From: Anita Gardner <Anita.Gardner@arun.gov.uk>
Sent: 21 July 2020 16:17
To: Planning.Responses <Planning.Responses@arun.gov.uk>
Subject: FW: AB/63/20/DOC 74-76 Canada Road

From: Laura Gibbons [REDACTED]
Sent: 21 July 2020 15:34
To: Planning.Responses <Planning.Responses@arun.gov.uk>
Cc: Anita Gardner <Anita.Gardner@arun.gov.uk>
Subject: AB/63/20/DOC

We have the following comments regarding condition 9:

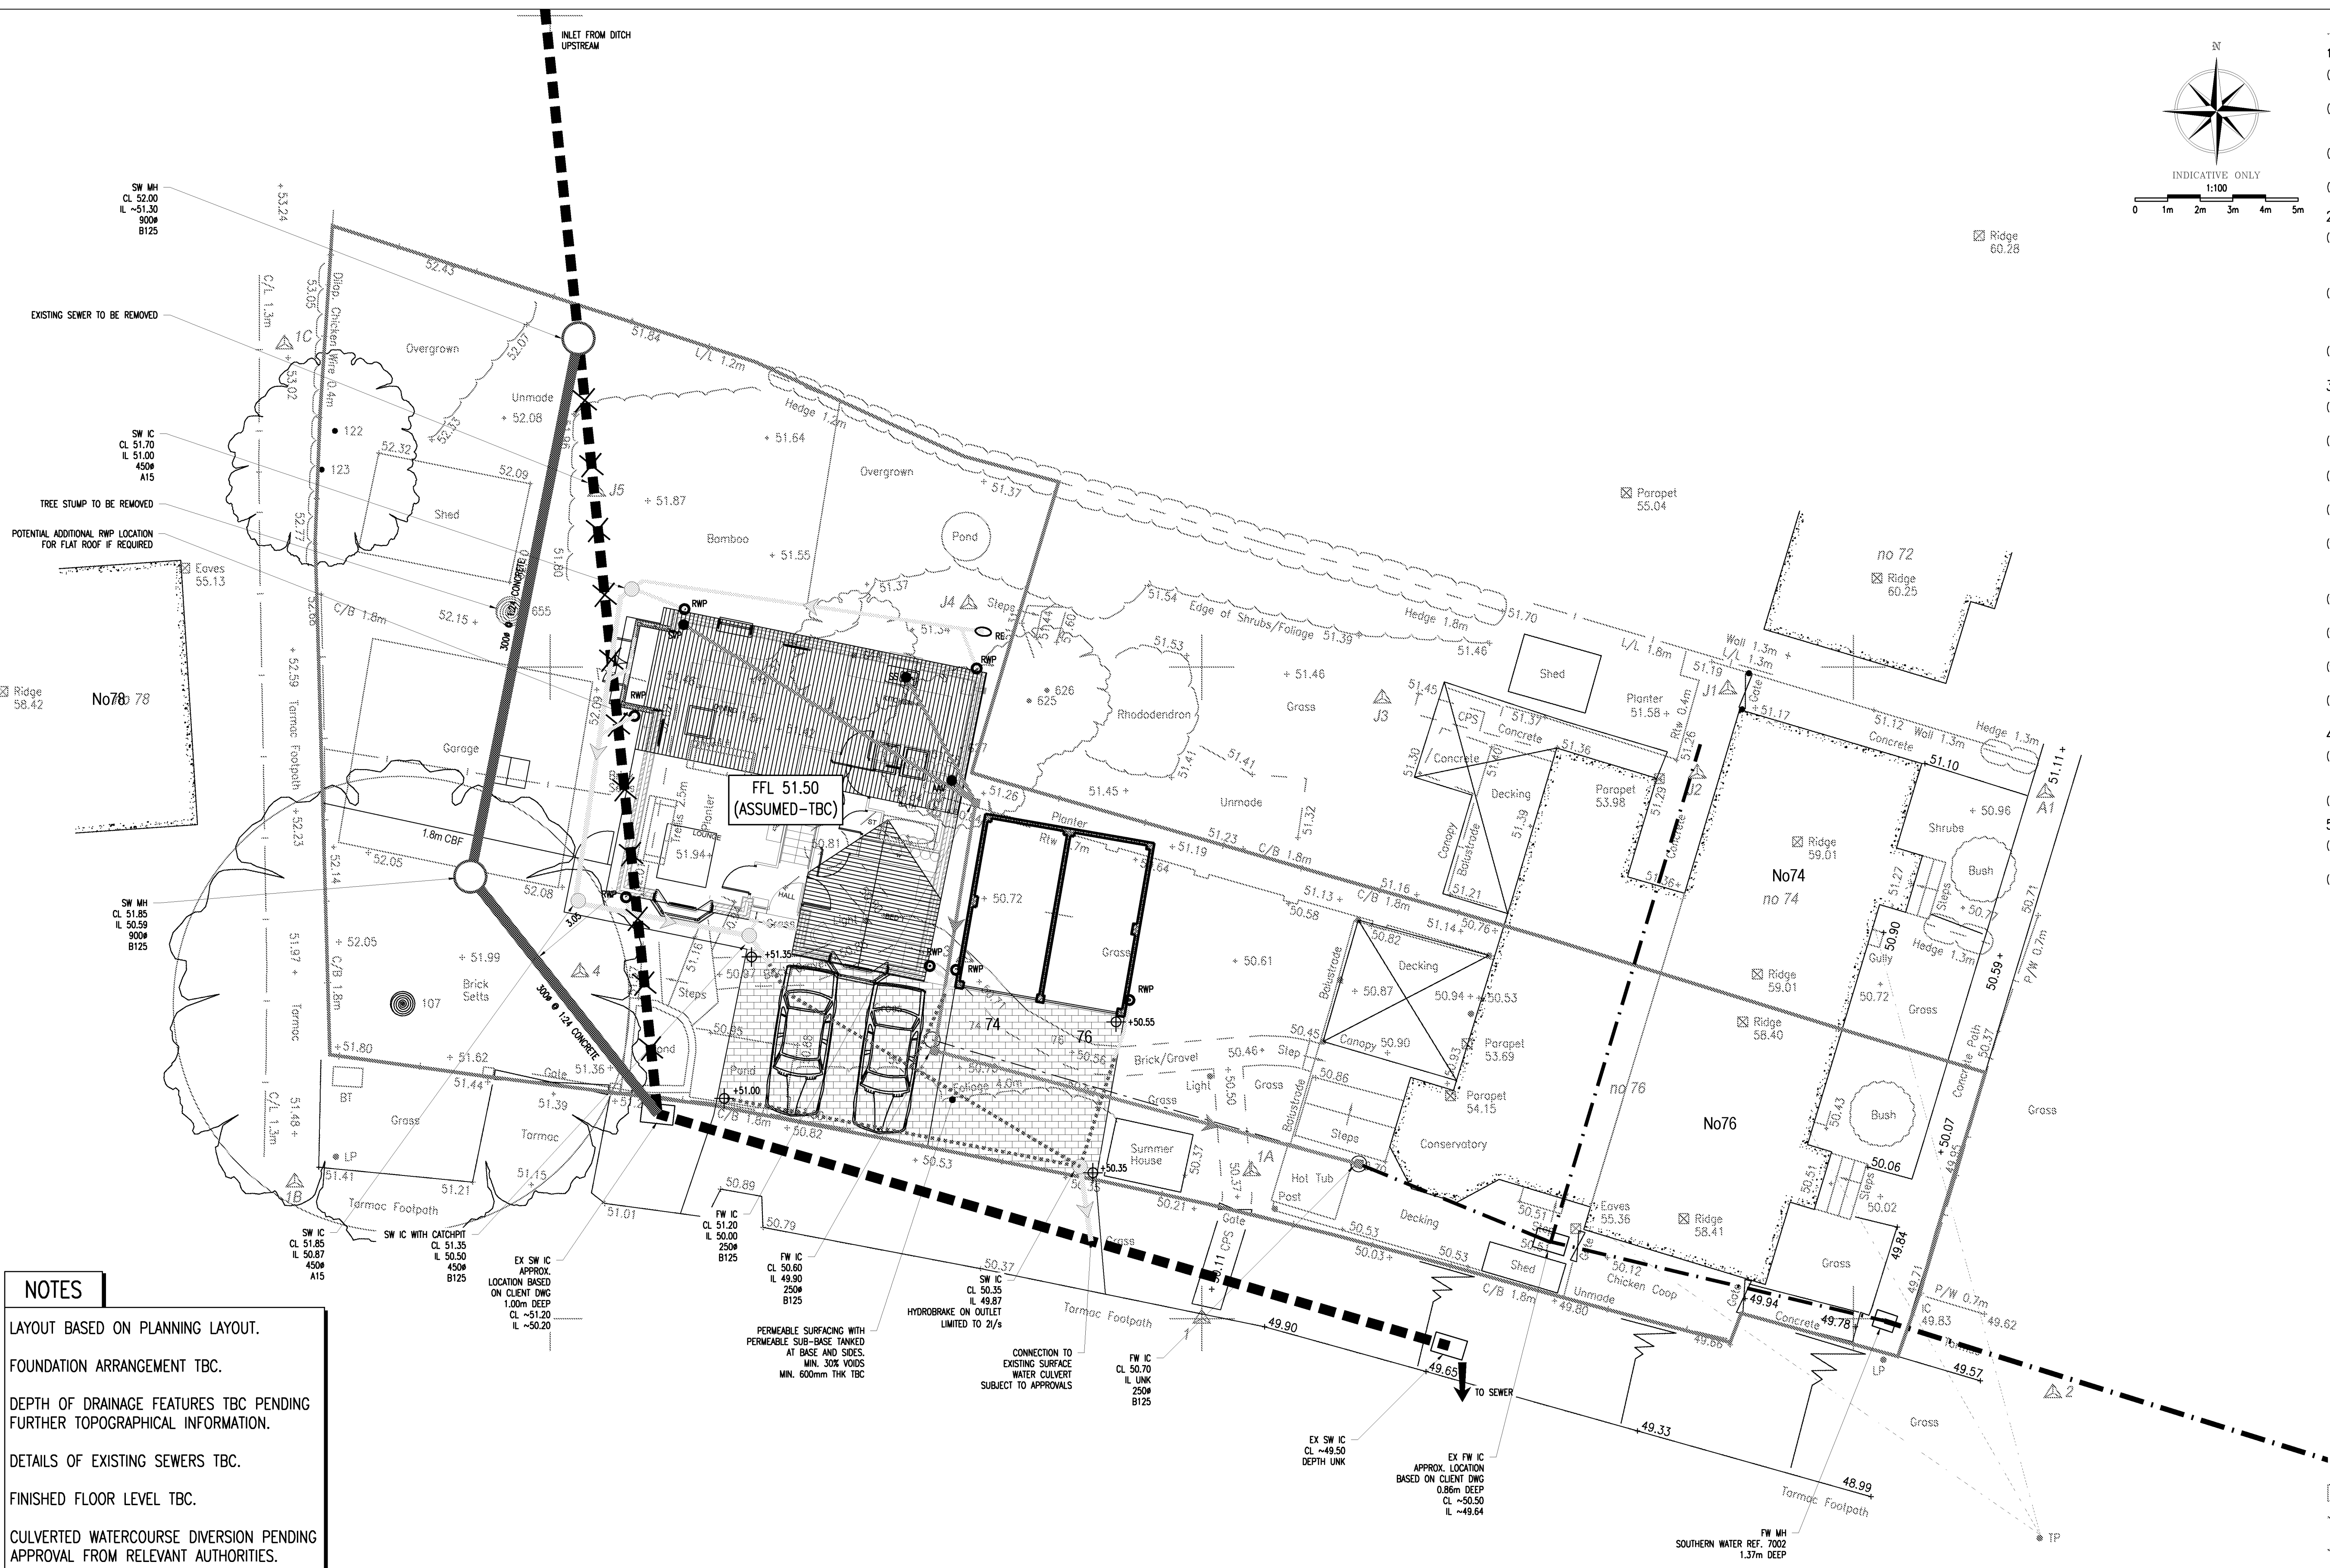
1. Please can a site specific construction detail drawing of the hydrobrake be provided.
2. Please adjust layout to include silt traps prior to all connections to permeable paving on plan.
3. Please provide finish and formation levels of permeable paving.
4. Please provide dimensions and construction detail for permeable pipe through sub-base.
